Application Ref:	3/2025/0913			 <p>Ribble Valley Borough Council www.ribblevalley.gov.uk</p>
Date Inspected:	17/03/2026	Site Notice:	n/a	
Officer:	MC			
DELEGATED ITEM FILE REPORT:				APPROVAL

Development Description:	Proposed redevelopment of existing dwelling to include demolition of existing conservatory and single storey side extension; raising the roof height to provide first floor living accommodation to include 3 no. pitched roof dormers; installation of Juliet balcony; alterations to fenestration and erection of open front porch.
Site Address/Location:	The Rochfords, Longridge Road, Hurst Green, Lancashire, BB7 9QW

SHEET: PROPOSED ELEVATIONS 1

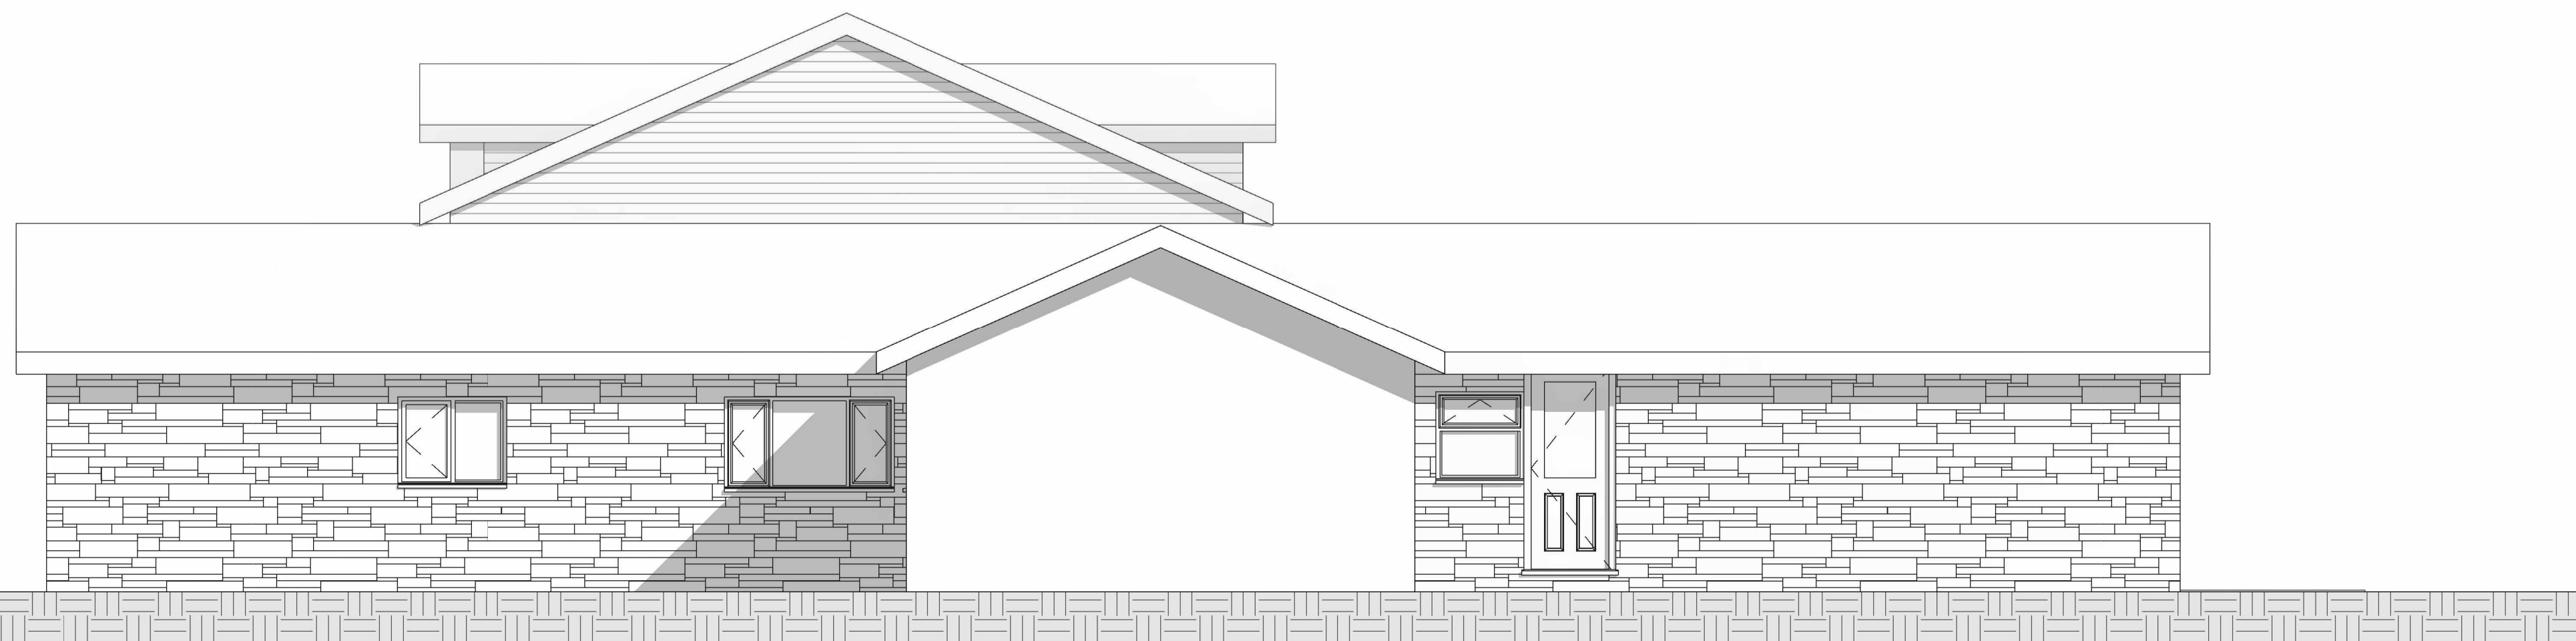
The introduction of a Juliet balcony to the East elevation could increase overlooking to the properties to the South-East of the dwelling. However, given the significant distances at over 100m, this is not considered to be adverse.

The proposal would involve the raising of the roof height to accommodate a first floor. This is considered to be acceptable, with the addition of 3 no. pitched roof dormers which are appropriate in size and scale to the roof slope. The large, glazed apex has now been amended to constitute a smaller width Juliet balcony with glazed balustrade. This is again considered to be acceptable as the glazing is not as extensive or as prominent as previously proposed.

SHEET: PROPOSED FLOOR PLANS

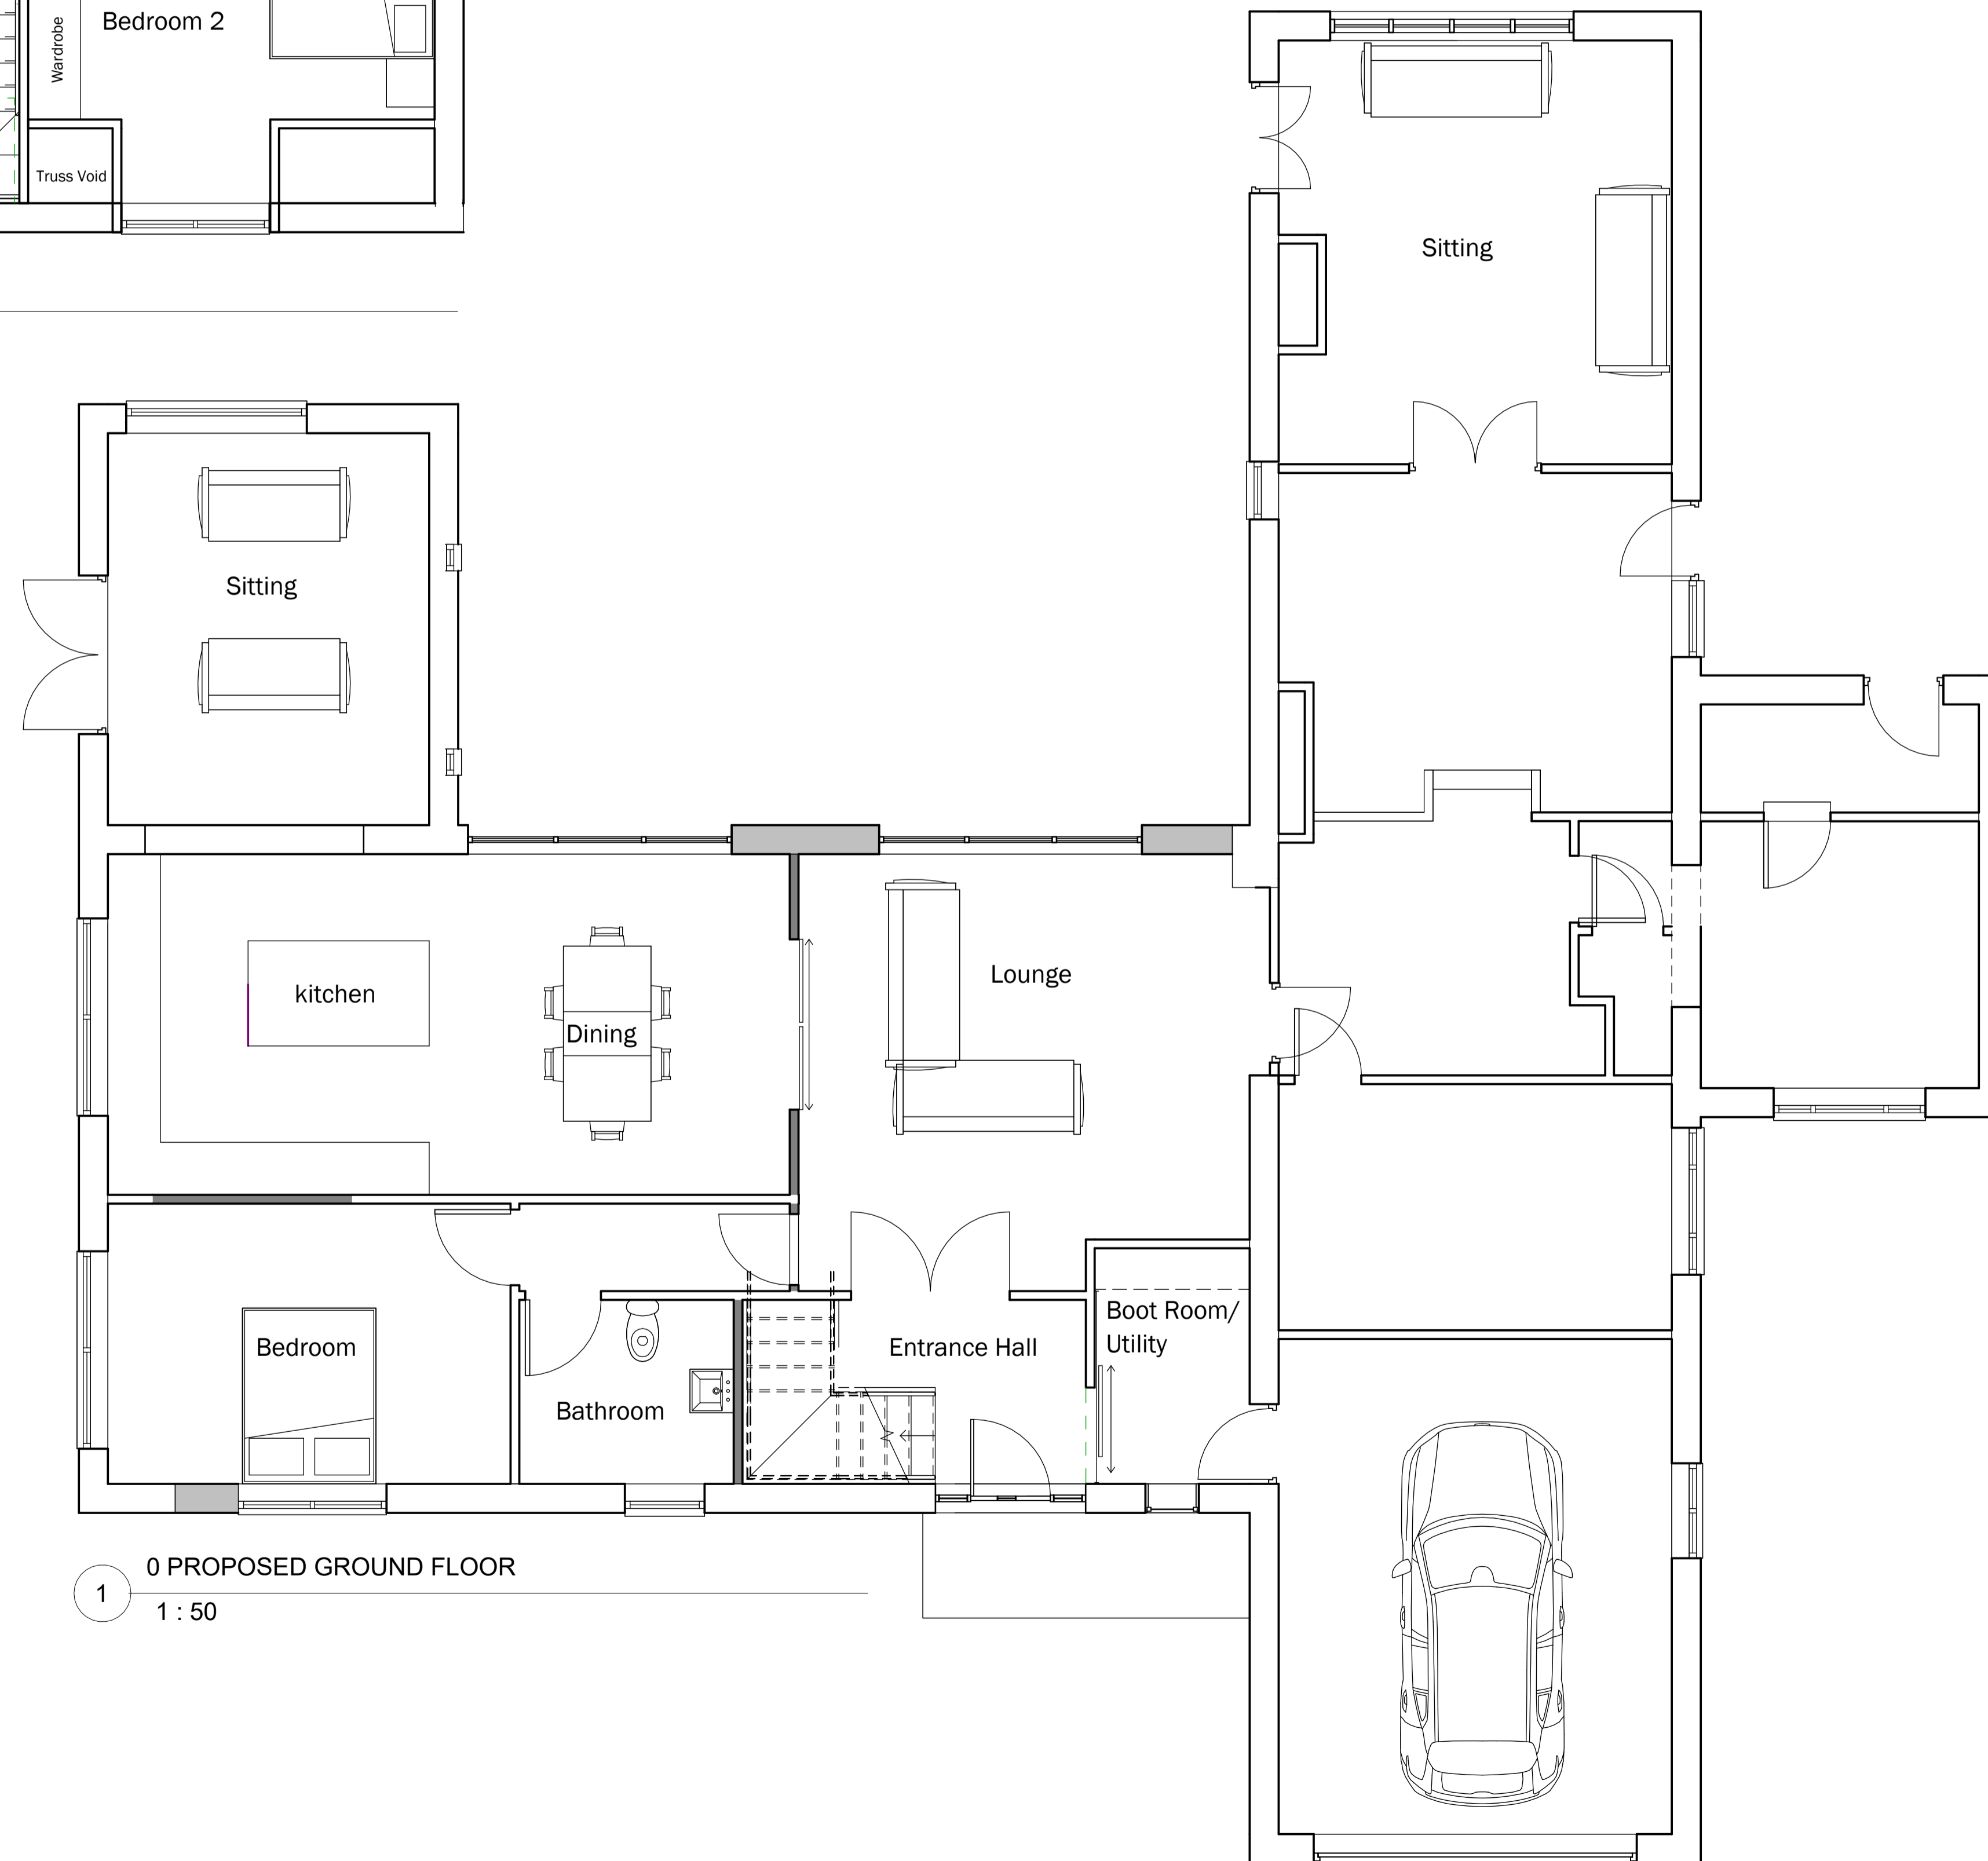
The proposal would involve the erection of a flat roof contemporary front porch area which would not be highly visible from the public realm and is acceptable. No objection is also raised to the conversion of the existing bedrooms labelled 'Bedroom 1' and 'Bedroom 2' to a garage with the insertion of a garage door on design grounds.

SHEET: PROPOSED SITE PLAN

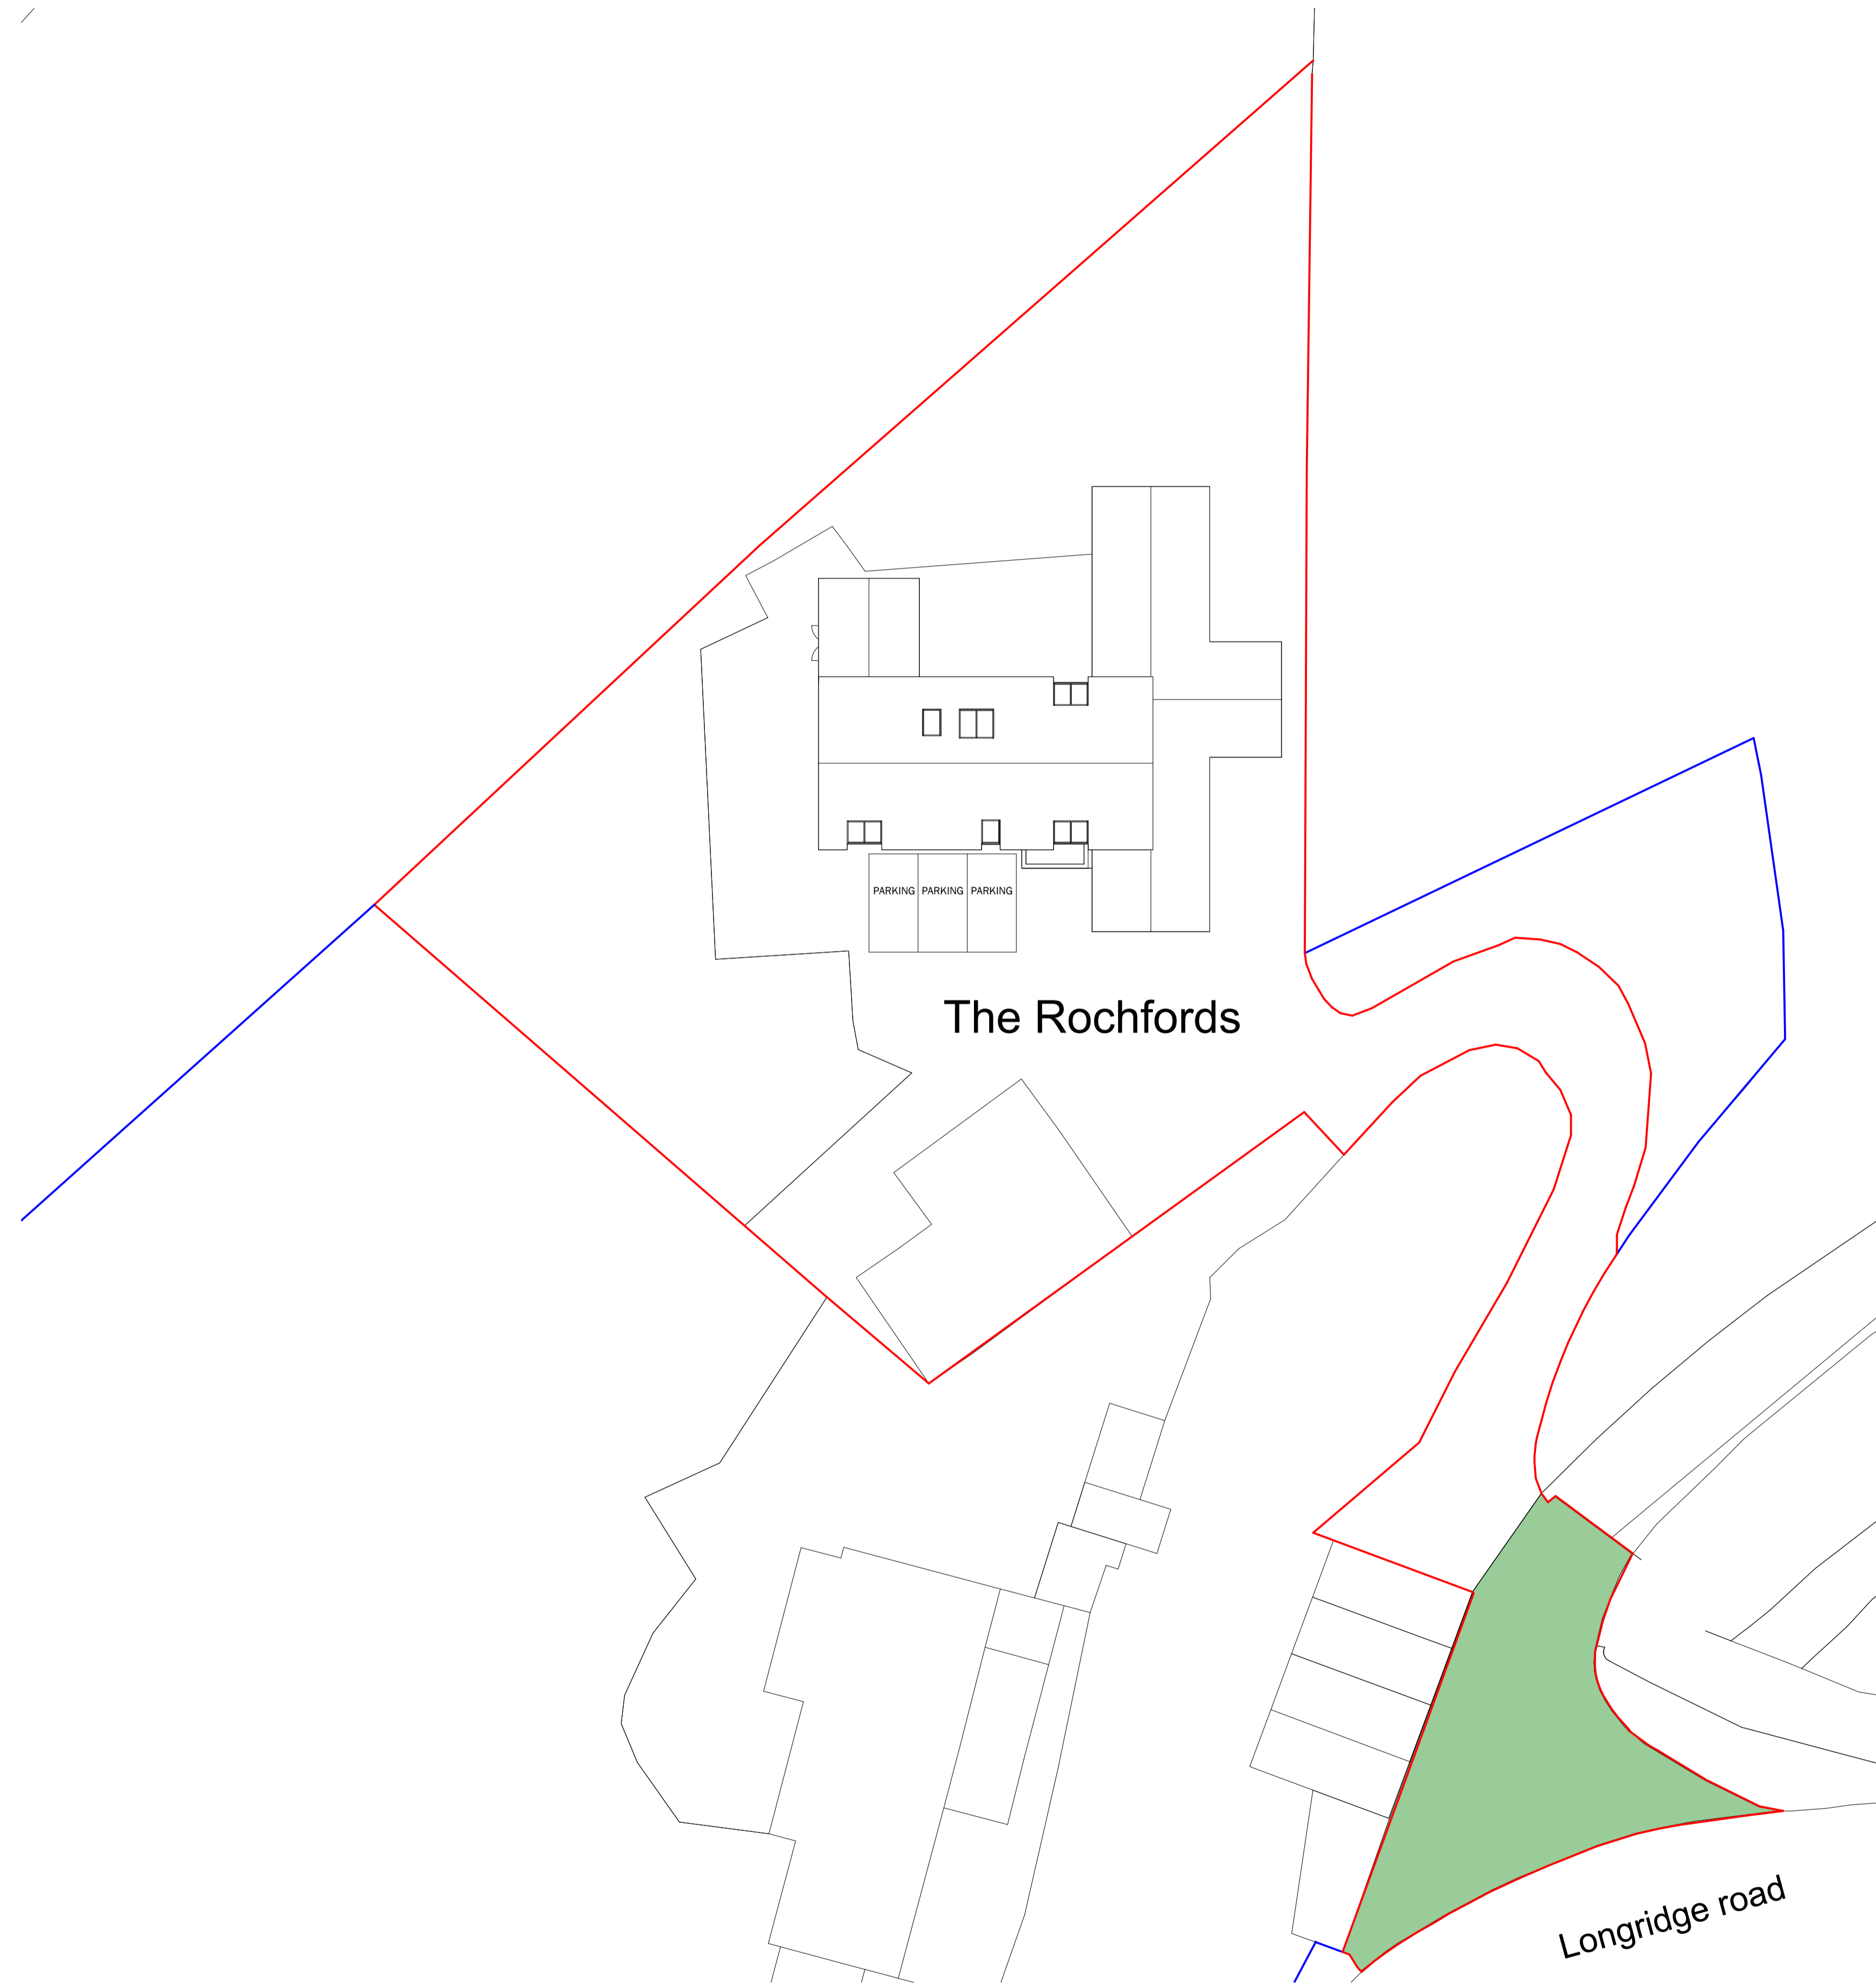
The Local Highway Authority (LHA) have been consulted on the application and they note that the site would be accessed via the existing access. They consider that the level of parking is in accordance with the LHA’s parking standards and there is also room to turn within the site allowing for ingress and egress in forward gear. Whilst the garage does not meet the internal dimension size to be counted as a formal parking space, the site would provide 3 no. parking spaces in addition to the garage which is considered to be acceptable.
